RESPONSE TO SUBMISSIONS REPORT

ALEX AVENUE PUBLIC SCHOOL_SSD_9368

JUNE 2019
P4090
PREPARED FOR DEPARTMENT OF EDUCATION

PROPOSED TEMPORARY CARPARK PLAN

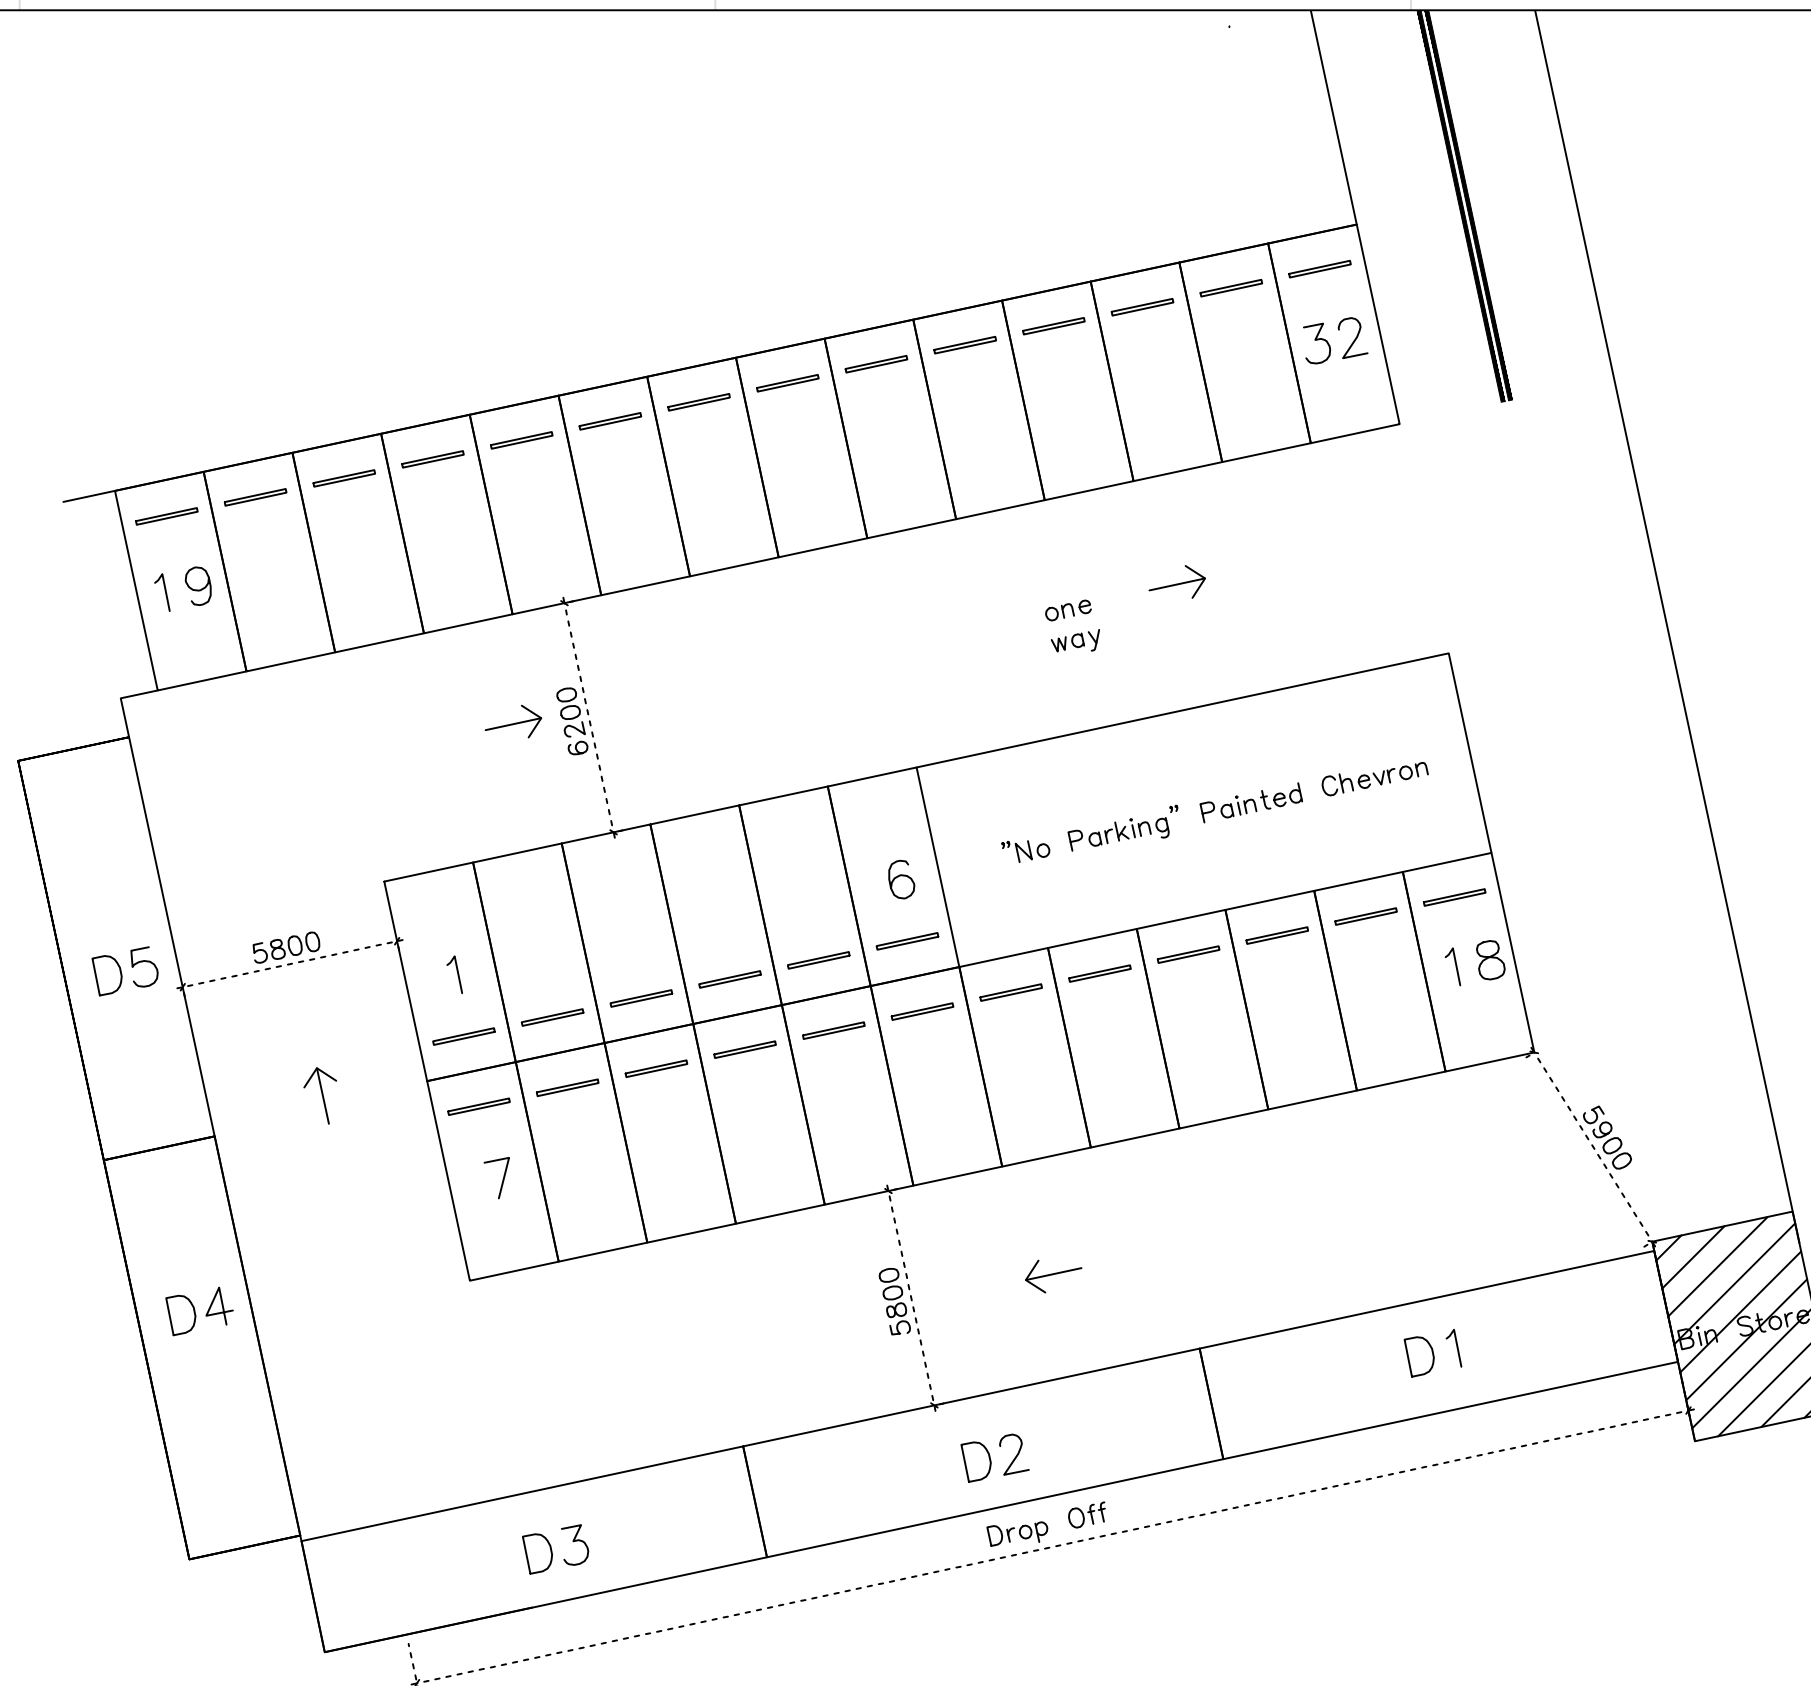
Issue	Comment	DoE Response	Reference
	<p>Roads and Maritime is responsible for speed limits along all roads within the state of New South Wales. That is, Roads and Maritime is the only authorised organisation that can approve speed zoning changes and authorise installation of speed limit/ school zone signs. Roads and Maritime will arrange for site inspection close to the completion of all construction works to determine the appropriate location of any new school zones or modification to existing zones. The applicant is to notify Roads and Maritime close to the completion of all construction works to allow enough time (8 weeks) for Roads and Maritime to gain approval for the speed limit changes.</p> <p>Roads and Maritime has noted that the proposal does not include any onsite car parking. Car parking for the school is proposed via the Council car park to be built directly adjacent to the site. The Council car park is intended to be shared between school staff and the community. Roads and Maritime request that the car parking be operational before the school is open to the public.</p>	<p>The future bus layby is located on Pelican Road, adjacent to the west side of the school. A pedestrian entry is planned immediately next to the bus layby, providing direct access for students arriving or leaving school via public transport. Due to limited carriageway width and volume of vehicular traffic on Farmland Drive, the school bus service is expected to operate via Pelican Road.</p> <p>Noted. No further response required at this stage. Roads and Maritime is the only authority capable of implementing speed zones, including temporary speed limits (including roadworks speed zones). If required to by project scheduling, Bitzios recommends liaising with Roads and Maritime in advance to confirm an early implementation of school zones.</p> <p>Noted. As indicated in earlier comments, in lieu of Council's car park being ready in time for the School's opening, alternative temporary parking and waste arrangements have been prepared with plans provided at Appendix R.</p>	<p>Appendix R</p>
